City of Albuquerque

May 11, 1999

**RE: ENGINEER'S CERTIFICATION FOR LOT 29 RICHFIELD PARK (C-17/D2A31)
RECEIVED APRIL 16, 1999 FOR TEMPORARY C.O.
ENGINEER'S STAMP DATED 4-16-99**

C-1

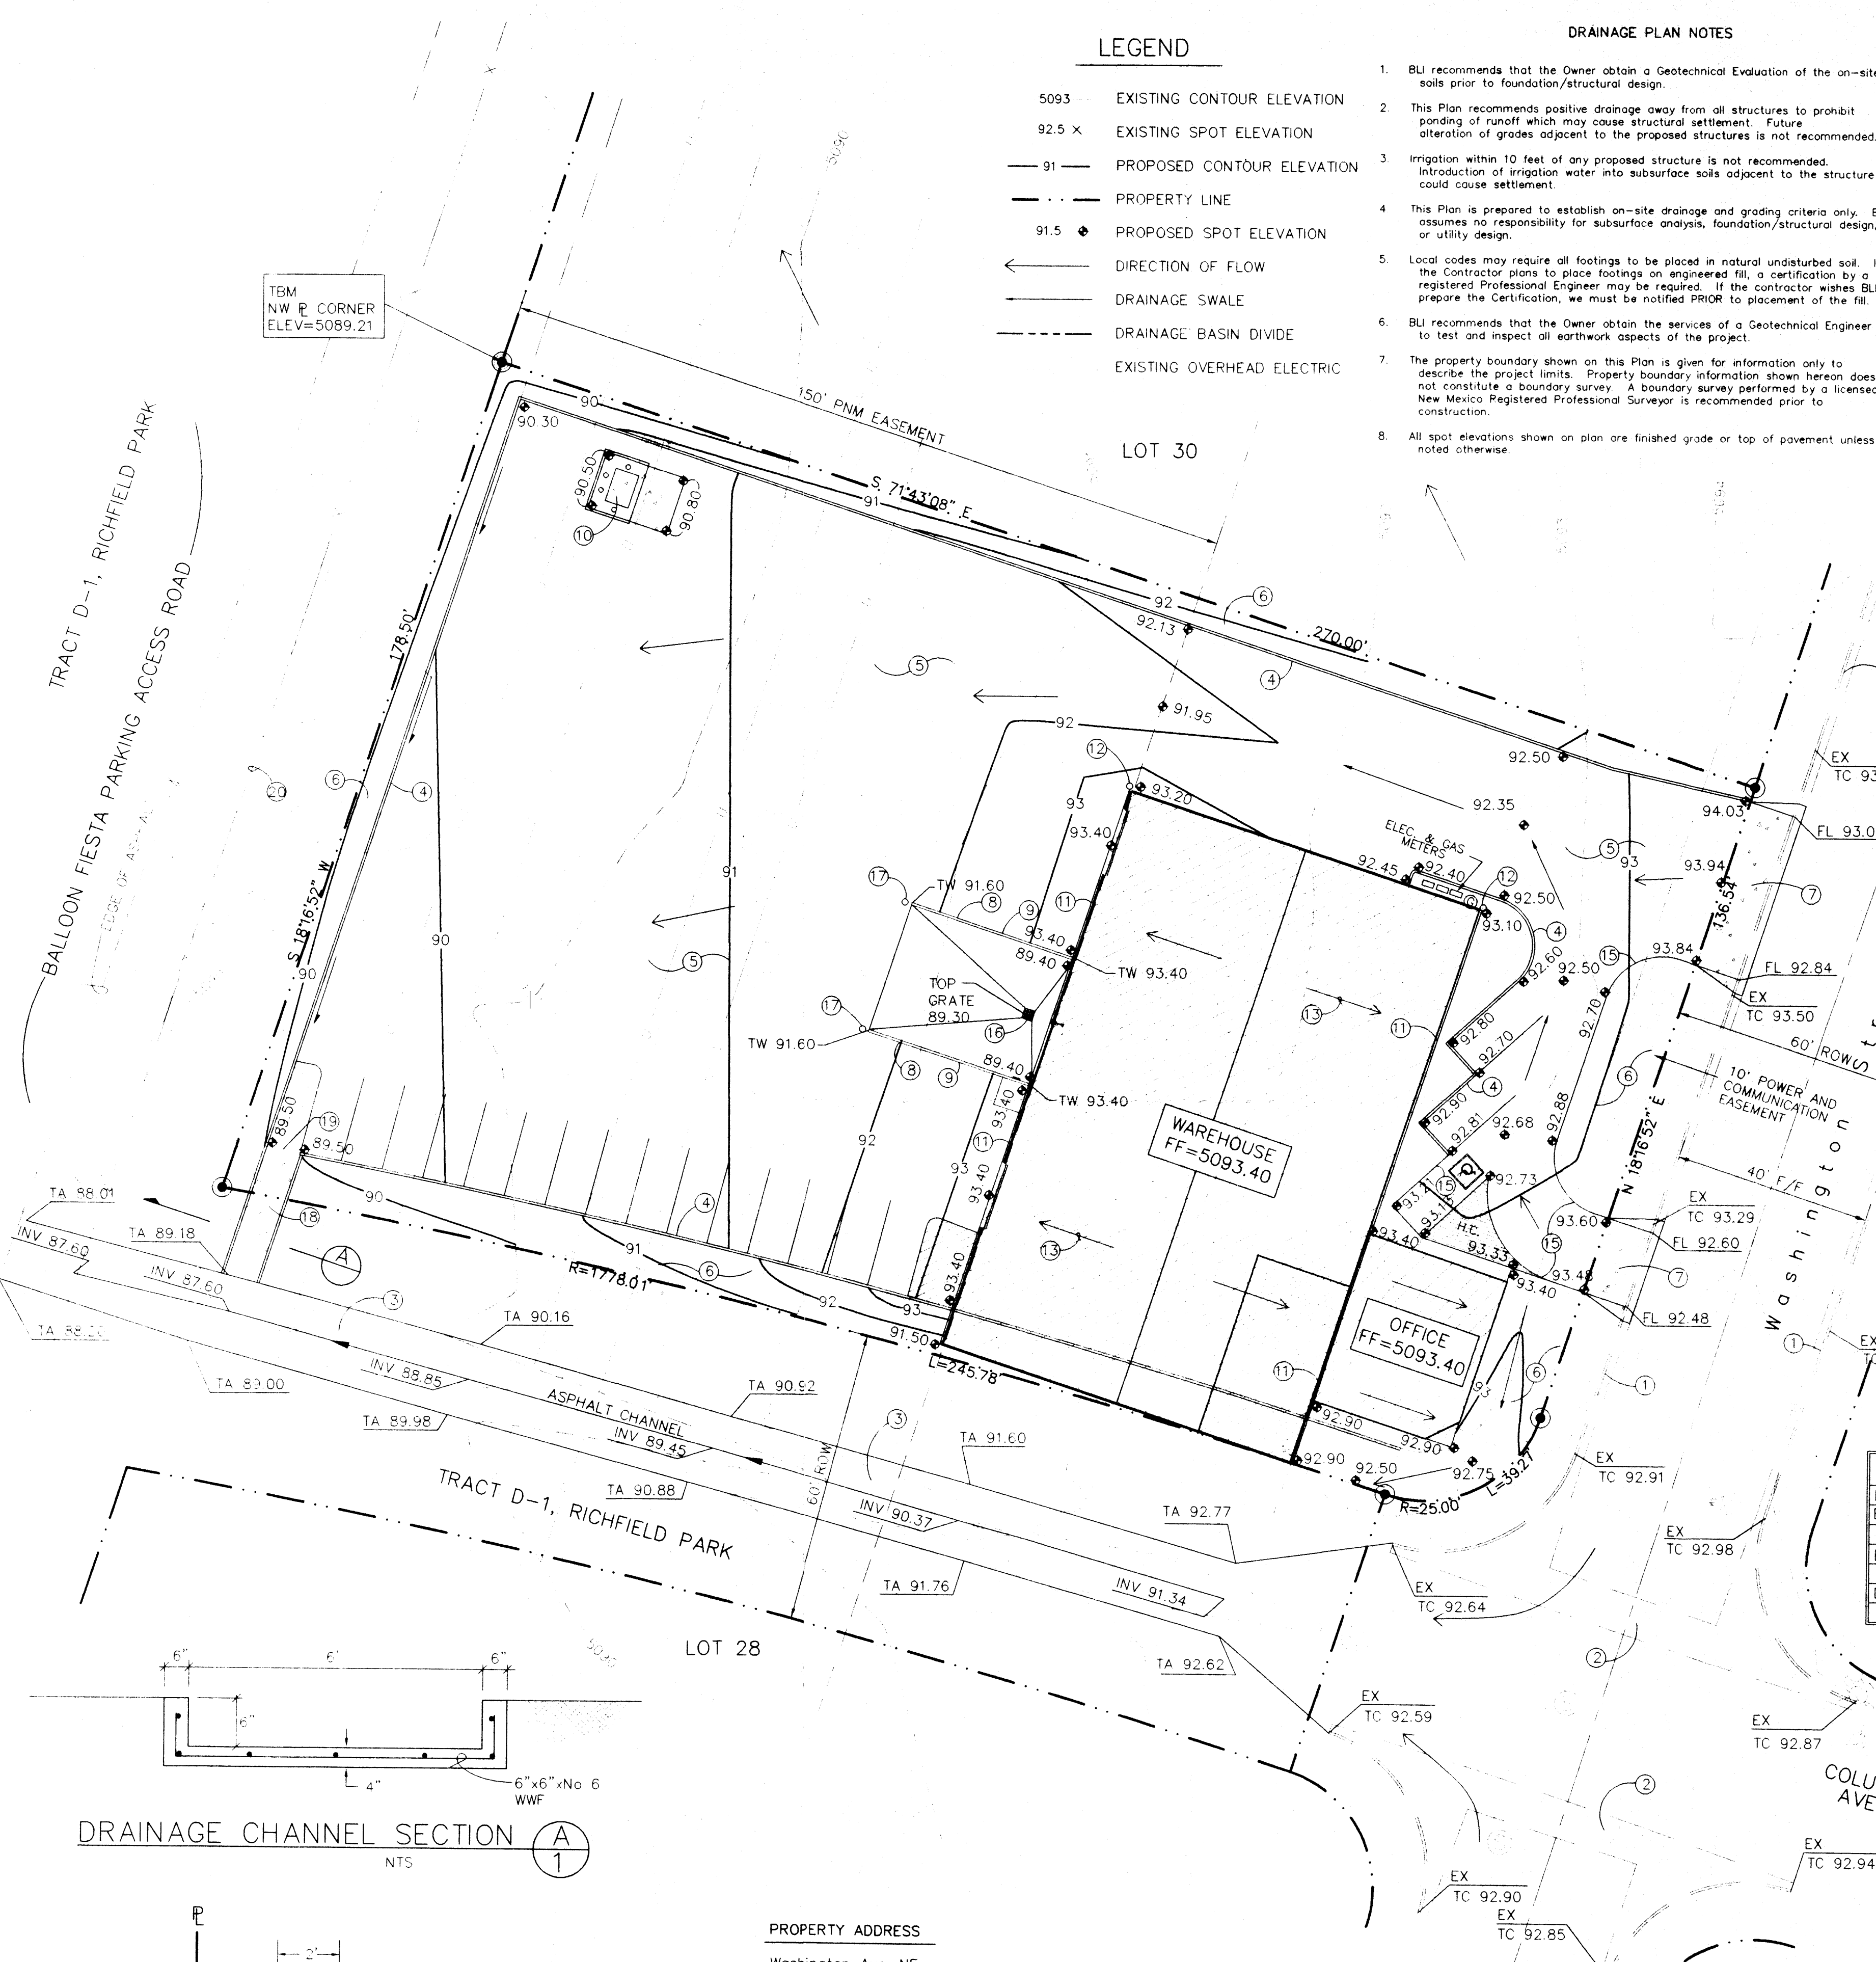
The approved plan was dated September 25 instead of September 9. Indicate the as-built F.F. elevation. Will the refuse enclosure trap runoff? When the north drivepad was revised, was the asphalt curb relocated? The water blocks at the drivepads appear to be about 2" less than proposed. Are they adequate?
